14th July 2020

Application No: BE/48/20/PL
Site Address: Land adjacent to Liseve Lodge 84 North Bersted Street Bersted PO22 9AQ
Description of works: Demolition of existing outbuildings & erection of 1 No dwelling. This application is a Departure from the Development Plan, affects the character & appearance of the North Bersted Conservation Area & may affect the setting of a listed building.

Thank you for your internet representation made on 13th July 2020 which has been recorded as an objection with the comments as follows:

CLIENT	Mrs L Parker	DRAWING	002 Proposed F.Plans & Elevations		
SITE	84 North Bersted Street, Bognor Regis	DATE	09 06 20	AUTHOR	AH
PROJECT	Proposed New Dwelling	SCALE	1: 100 @ A3	STATUS	PL

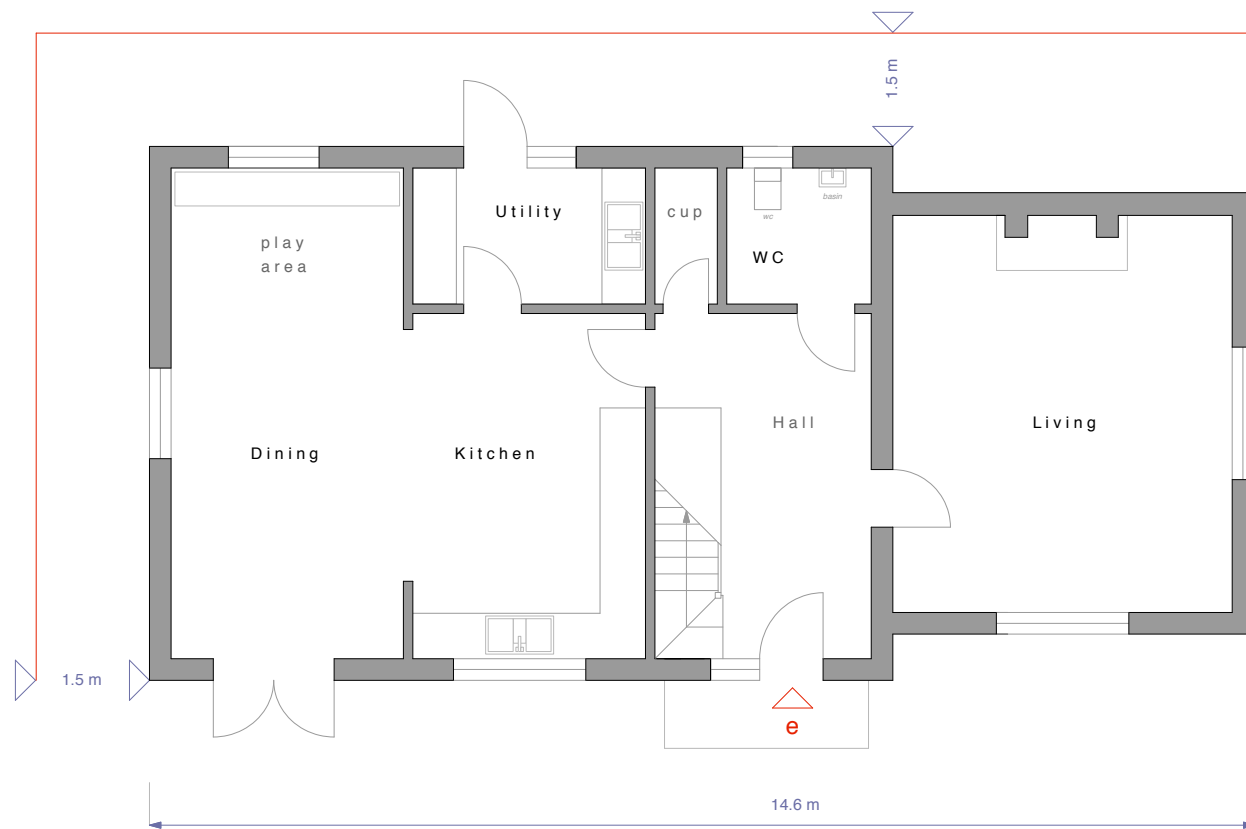
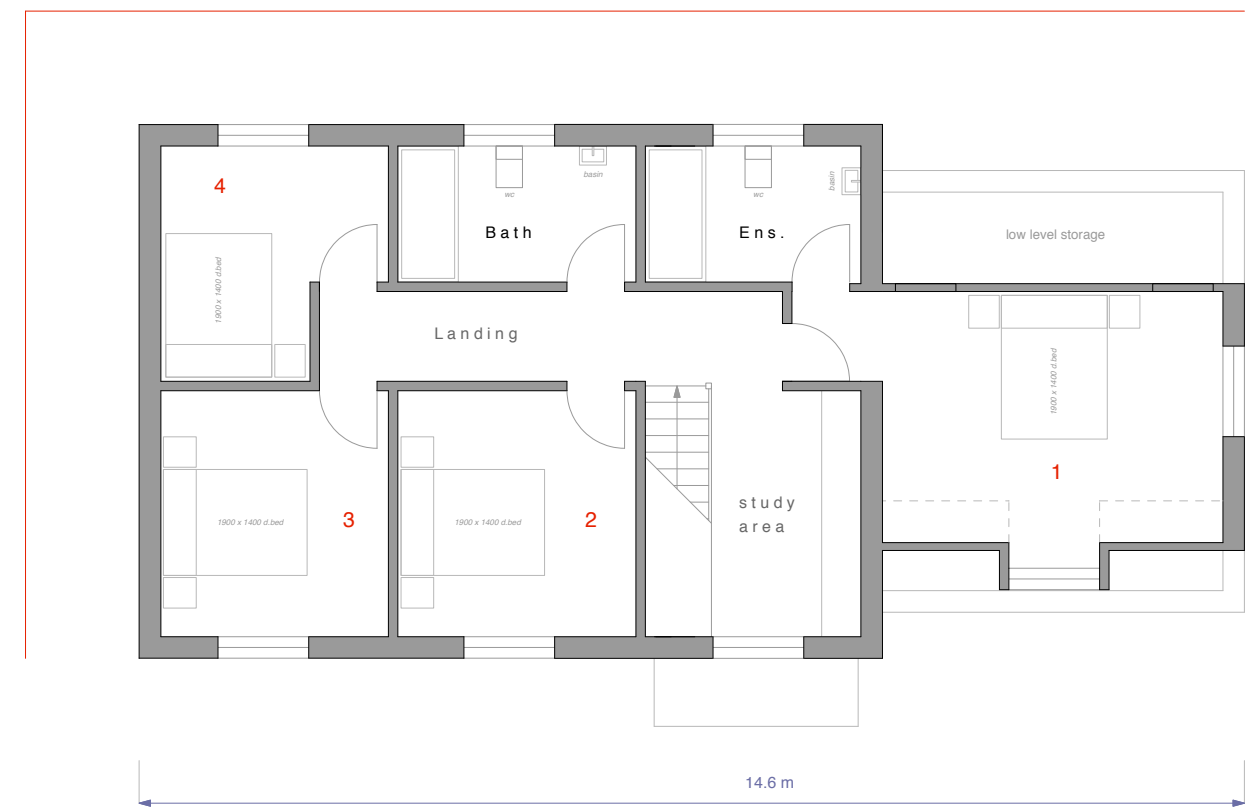
The proposed building itself appears to sit well within the landscape and makes use of similar materials to the existing small house on the site although it would be important to ensure that construction materials are of a relevant quality and grade so as to ensure continuity of the rural aspect of the site.

However, in terms of environmental impact within the conservation area, important details appear to have been omitted. Access for cars is not made clear on the plans which also suffer from very faint writing making all details difficult to decipher. It may be that P1 and P2 are either parking spaces or garages but this is not noted on the plans and 2 parking spaces are considered insufficient for a 4 bedroomed house. particularly in this wooded area in a conservation area (Arun Local Plan policy T SP1, the Councils Parking Standards supplementary planning document (January 2020) and the National Planning Policy Framework (2019).

CLIENT	Mrs L Parker	DRAWING	004 Site Layout Plan (Tree Context)		
SITE	84 North Bersted Street, Bognor Regis	DATE	16 06 20	AUTHOR	AH
PROJECT	Proposed New Dwelling	SCALE	1: 200 @ A3	STATUS	PL

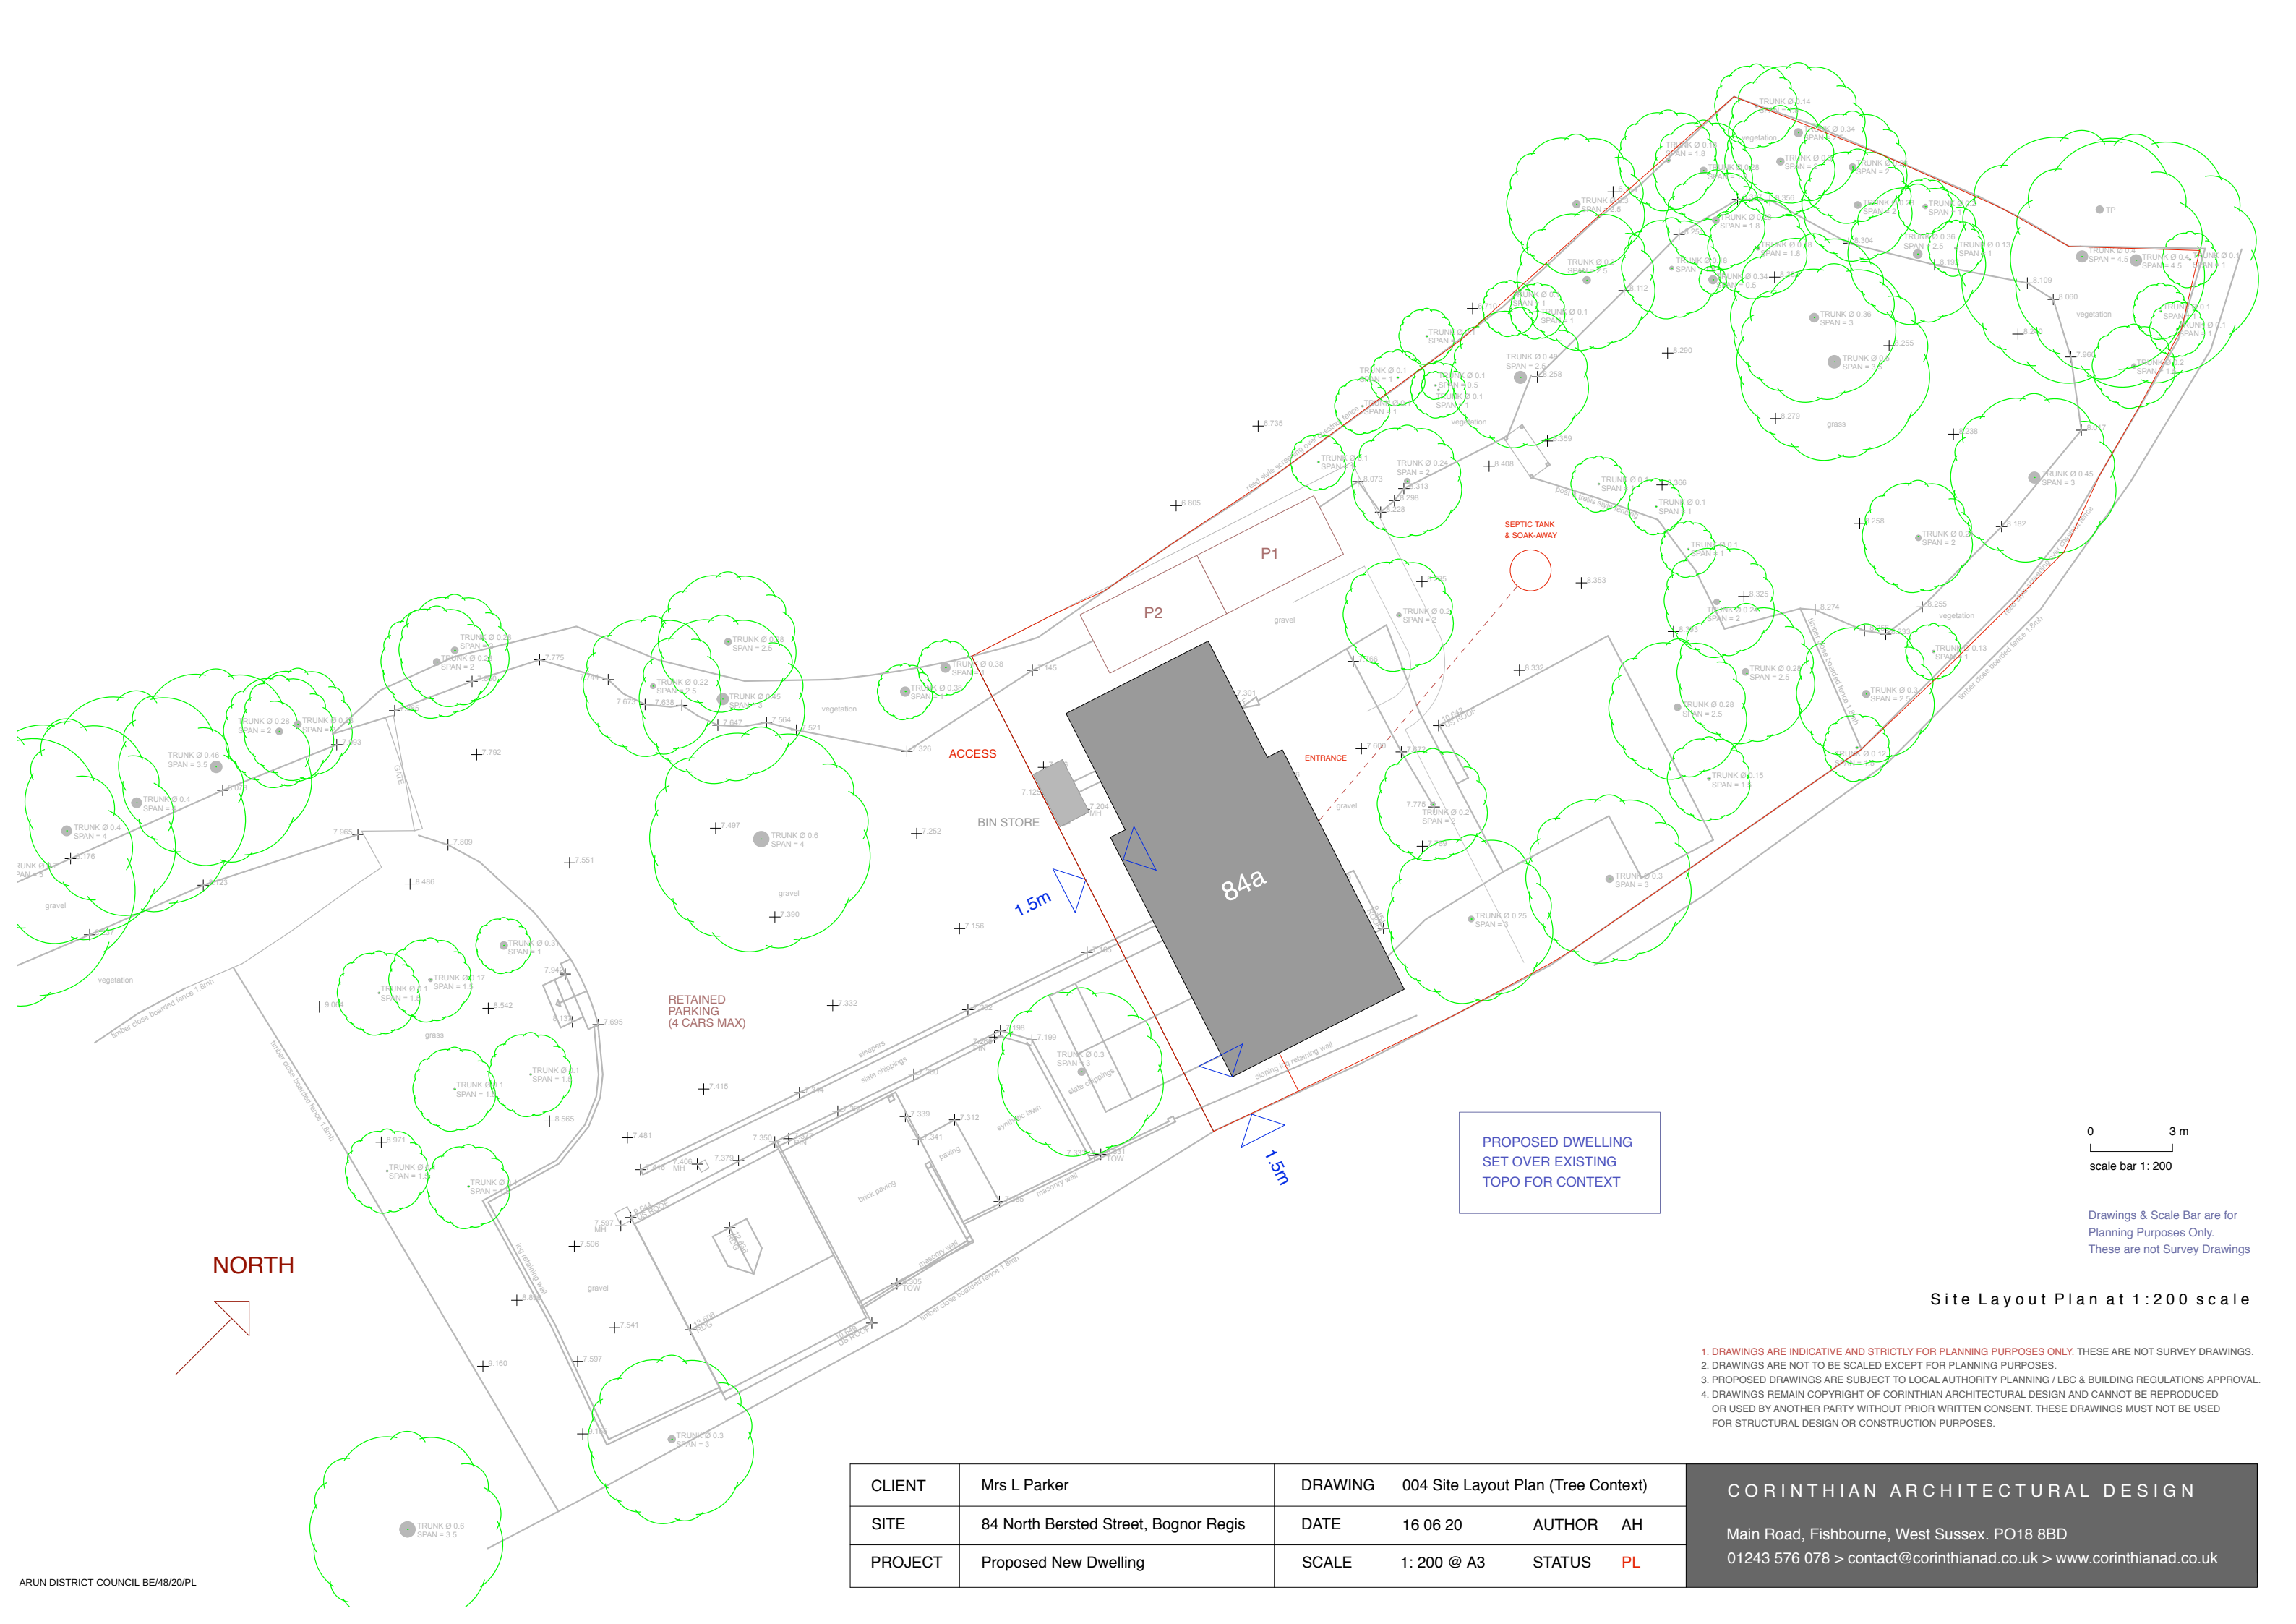
The trees are an important feature of this part of the conservation area and it is unfortunate that the tree survey data is encoded making it difficult to see which trees are proposed for felling as there are some large outstanding trees of amenity value which add to the semi-rural environment and are integral to this part of the conservation area. Should the building be approved, it is strongly advised that the ADC arborculturalist is involved in the project. Until further information is provided regarding the setting of the dwelling, it is recommended that this application is deferred/refused.
